**KIRKLEES METROPOLITAN COUNCIL  
INVESTMENT & REGENERATION SERVICE**

**DELEGATED DECISION TO DETERMINE PLANNING APPLICATIONS**

Reference No:	<b>2024/62/91585/E</b>
Site Address:	The Lodge, 4, Beaconsfield Farm, Paul Lane, Flockton, Wakefield, WF4 4BP
Description:	Change of use of land from agricultural to domestic curtilage and erection of single storey side extension
Recommending Officer:	Edward Cheseldine

**DECISION – REFUSED**

Block Plan as Proposed

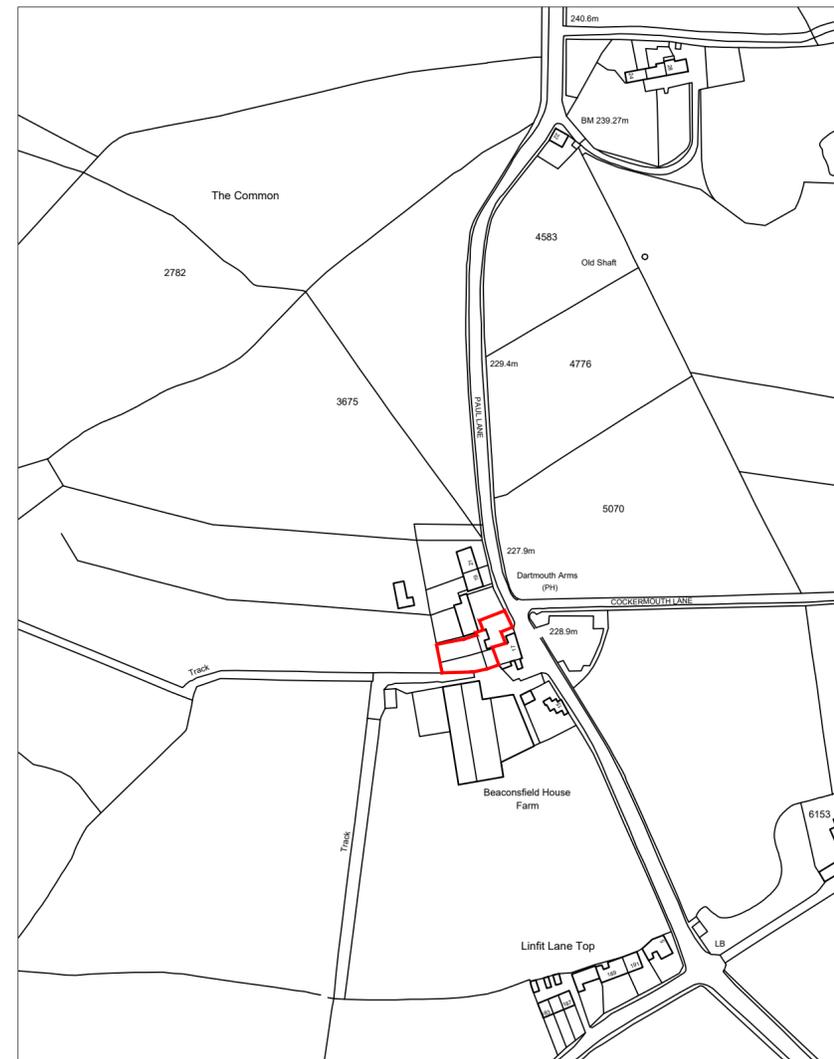
In terms of a spatial assessment, the built material will be sprawled across the site, extended beyond the built form as it stood in 1948. The planning unit will therefore have extended southwards by a significant distance. This extension draws the built form away from the original building, forming an incongruous addition shifting its footprint to the south. The property has already benefitted from a rear extension pursuant to 2005/93725, which has modified the original west facing elevation. The proposed addition further disrupts the original footprint of the building, altering it from a simple 'L' shape to an elongated form. It would form disproportionate additions over and above the size of the original building due to the continuous, snaking, form and development far beyond its original footprint.

In this instance, the applicant has suggested the land has previously been hard surfaced. Aerial imagery identifies part of the agricultural field has been surfaced since 2009. The plot of land leads to an agricultural building. It is likely the field has been surfaced for vehicular access, although there is no planning history to confirm this. The character of this part of the field has therefore changed over time. There is evidence that vehicles have been stored on the hard surfacing since 2015.

The application is for the erection of an extension upon an area where no built form has stood. The purposes of the land will therefore impact upon the openness of the Green Belt. It therefore cannot be stated that the application preserves the openness of the Green Belt as the extension conflicts with the purposes as a result of encroachment into currently open land. As stated in the previous section, the extension would represent inappropriate development due to disproportionate additions, elongated form and scale of the extension, forming additions that are not clearly subservient to the original building.

Therefore, for the purposes of LP58, the extension would not fall under the criteria for a garden extension within the Green Belt and the development is not considered to preserve openness and is considered to conflict with one of the purposes (encroachment) in this case contrary to paragraph 155 of the NPPF.

Ground Floor Plan
As Proposed

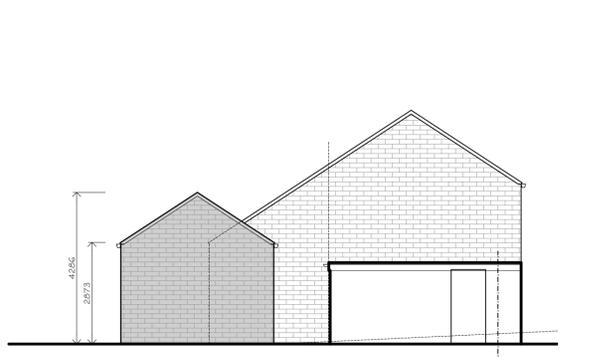
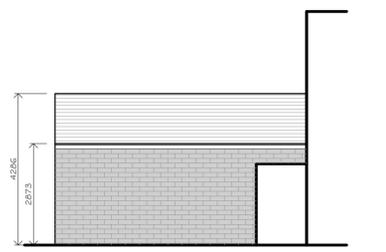
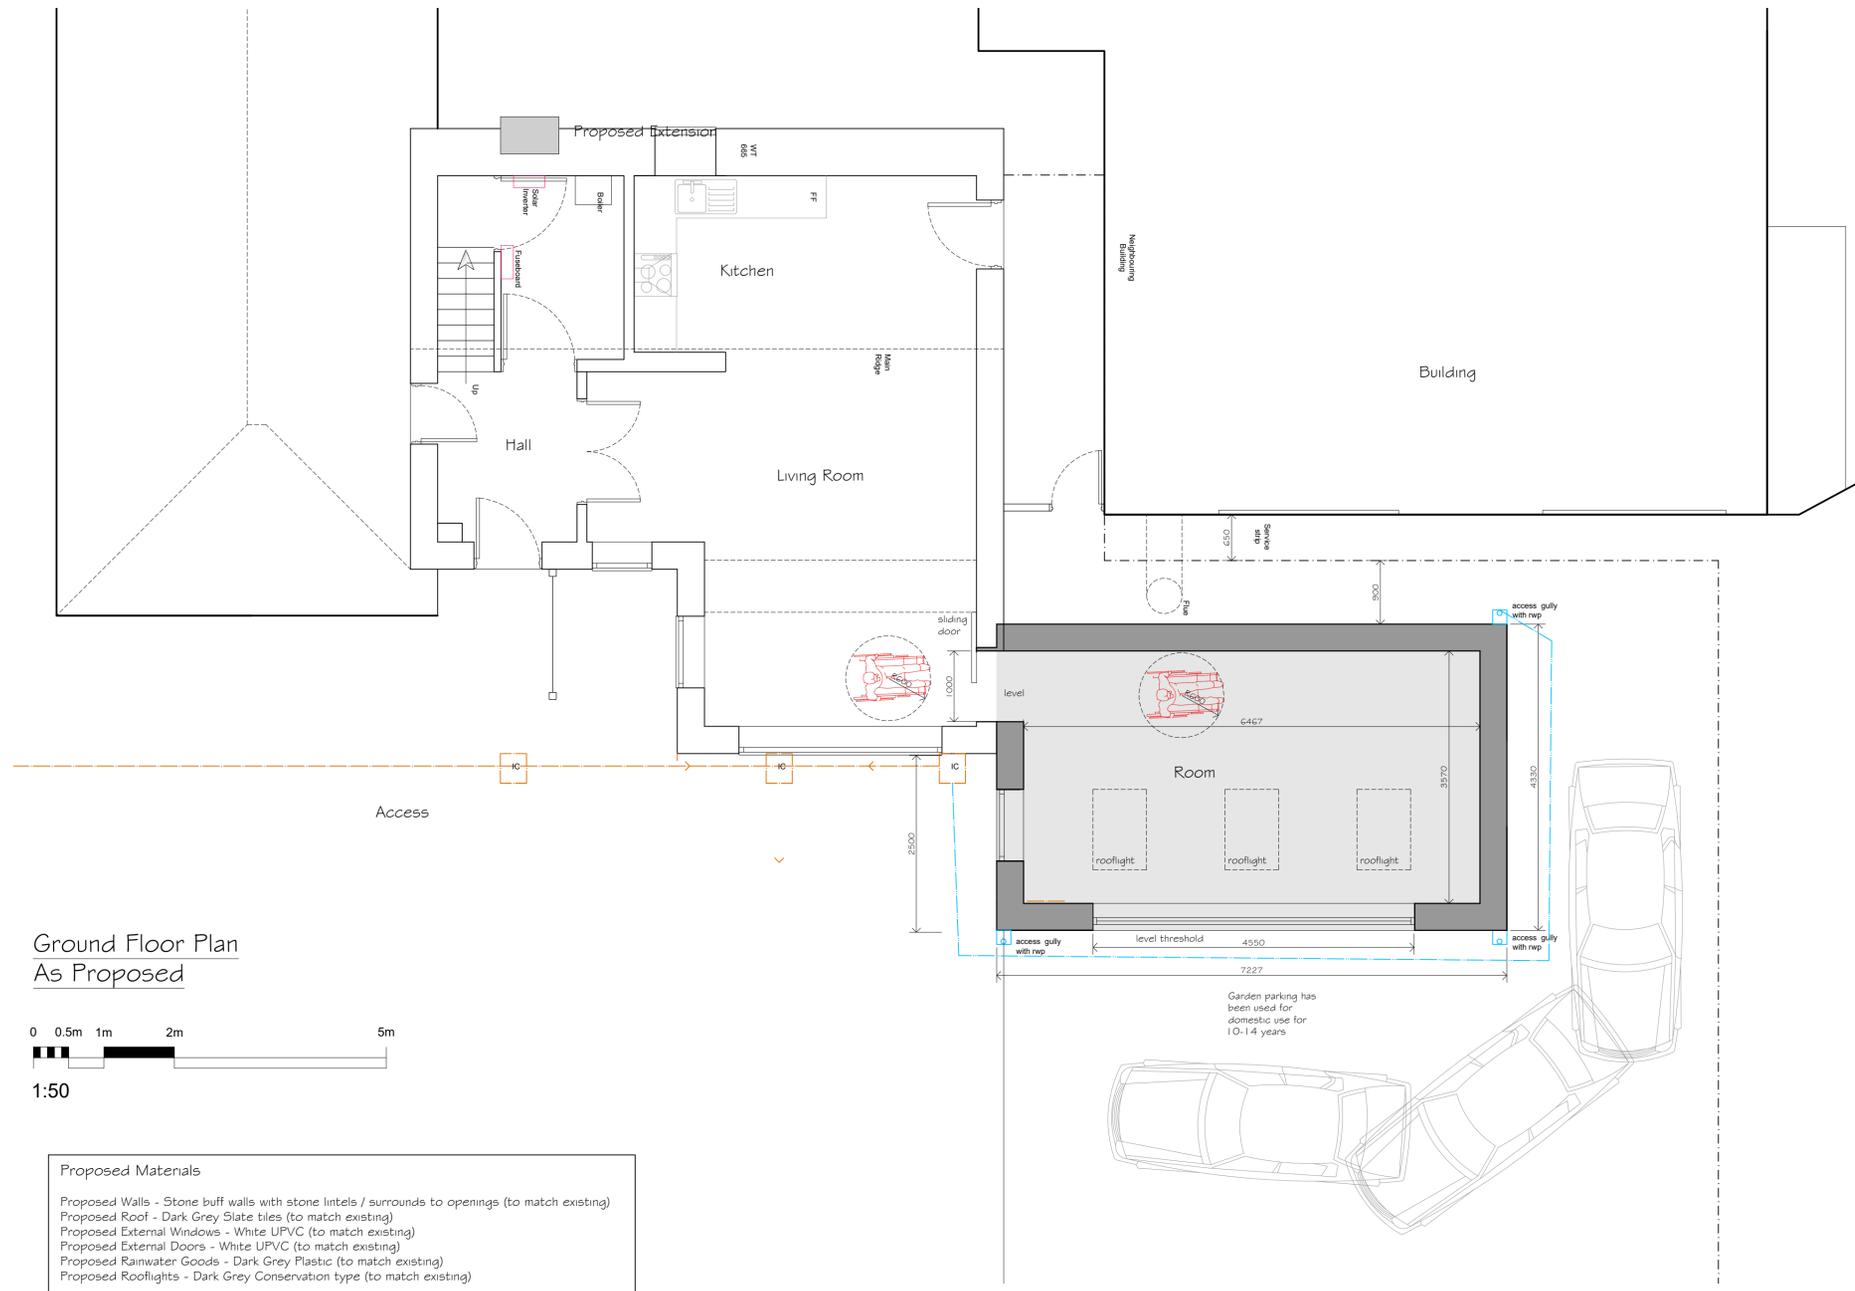
The proposal pertains a rear extension which is set to the side of the original building. It occupies a space in front of the rear elevation of the adjacent building. It has a high-pitched roof, with a ridgeline height of 4.286m. The extension competes with the original building when observed from the rear elevation due to its scale and ridgeline height. The building has already benefitted from an extension which has extended its roof form, although the property has retained its character and overall scale by forming a catslide roof. The rear extension will occupy a space of 7.227m(w) x 4.330m(d) within

a group of buildings. It will appear clustered creating a built-up aesthetic, which is neither integrates with the original dwelling, nor is sympathetic to the spacing of the building group, therefore introducing an appearance more commonly found within the urban environment.

In this case, the adjacent building has a restaurant use, in a relatively rural location. The extension will obstruct a rear facing window that serves the kitchen, and partially block the window of an office. Window outlooks are part of a safe and healthy working environment. Paragraph 96 c) of the NPPF states '*decisions should aim to achieve healthy, inclusive and safe places, which c) enable and support healthy lifestyles, especially where this would address identified local health and well-being needs*'.

It has been identified that the kitchen has a single outlook, would be ~1.50m from the extension. The eaves of the proposed extension would sit level with the top of the kitchen window. The outlook would therefore be reduced to none. The adjacent restaurant has an established use, obstructing the outlook of a room vital to the function of a business would be contrary to the needs of a rural business, whilst providing a poor working environment for staff and would not represent sustainable development as it would harm the economic function of an established business.

The application is for a side extension set rearward of the building line. In terms of Key Design Principle 1, the extension is positioned to the rear of the neighbouring building. The extension has an irregular placement that does not conform to the existing spatial layout of the building group. Although there is no fixed pattern to the collection of buildings, the extension fails to respect the adjacent building, sitting in front of the neighbouring property. There is a minimal separation space of ~1.50m between the extension and 17 Paul Lane which creates a narrow gap which should be avoided. Allowing the extension would present poor design in terms of spacing and layout which would be detrimental to the character of the area.

The scale, roof design and sitting of the extension fails to respect the original house. There is a significant increase in the footprint of the original dwelling due to the accumulation of extensions from the original property which would dominate the building when viewed from the rear. The scale of the extension is extenuated by its positioning. The extensions would form the dominant element of the original building. In addition, the pitched roof would appear higher than the catslide roof.

2. The proposed extension, due to its positioning and height, would impact upon the outlook of an existing restaurant, which would create a poor working environment for the neighbouring business that would be detrimental to the well-being of staff. To allow the development would harm an existing business and the health of associated personal contrary to paragraph 96 c) of the National Planning Policy Framework and policy LP10 of the Kirklees Local Plan.

3. The proposed extension, due to its scale and positioning, would appear unsympathetic to the original character and form of the dwelling, leading to an incongruous design that would be detrimental to the host building and character of the area contrary to Policy LP24 (a c & d), as well as Principles 1 & 2 of the Kirklees House Extensions & Alterations Supplementary Planning Document and policies within Chapter 12 of the National Planning Policy Framework.
